Addendum No. 1

RE: Contract ID C203743

US-17/NC-55 From Mill Street To Neuse River Bridge

The following revisions have been made to the sketch maps (plans):

PAVEMENT SCHEDULE

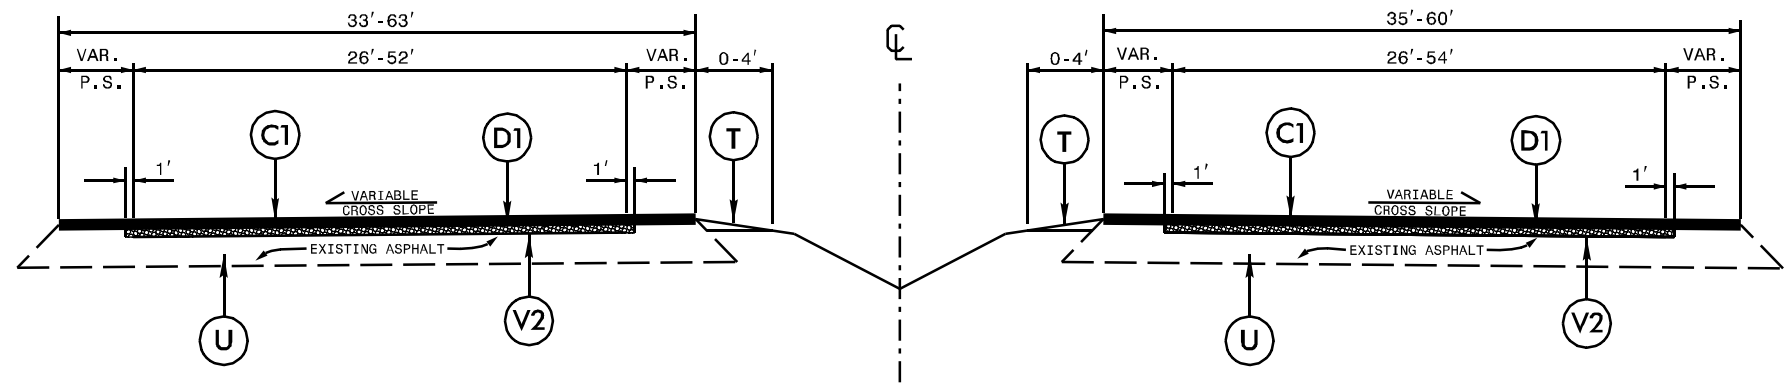
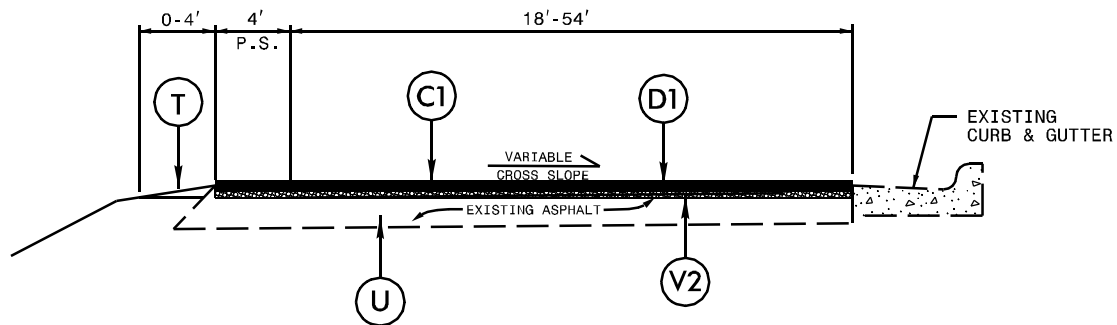
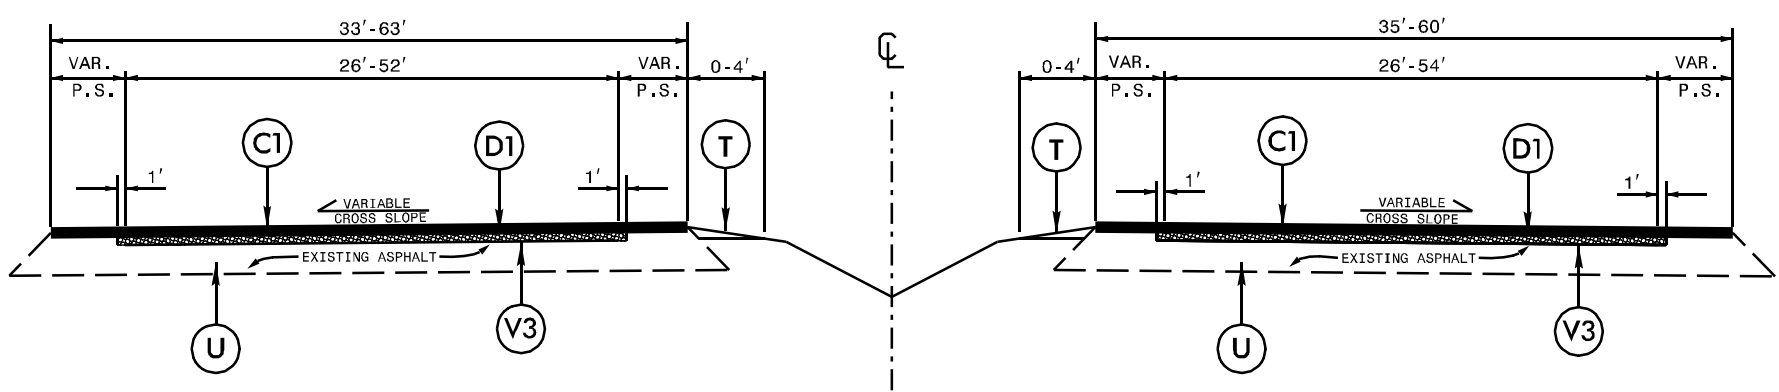
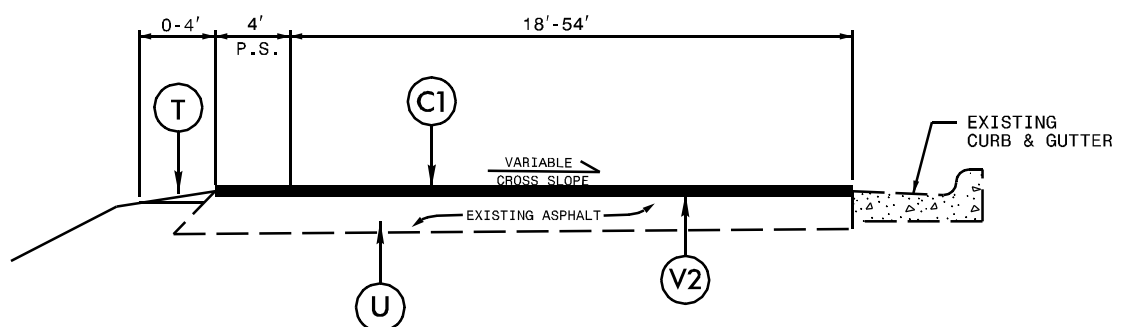
Sheet No.	Revisions
2	Revised the Pavement Schedule, Typical Sections No.1 and 2
4	Revised the Summary of Quantities to reflect the change to the Typical Sections and the below noted quantity changes and addition

<u>Item</u>	<u>Description</u>	<u>Old Quantity</u>	<u>New Quantity</u>
004-1297000000-E-607	Milling Asphalt Pavement, 2 ½" Depth(was 4 ½"Depth)	115,289 SY	110,283 SY
006-1498000000-E-610	Asphalt Concrete Intermediate Course, Type I19.0B	17,413 TON	16,635 TON
008-1575000000-E-620	Asphalt Binder For Plant Mix	1,913 TON	1,875 TON
014-1308000000-E-607	Milling Asphalt Pavement, 0" To 2"	NEW ITEM	5,006 SY
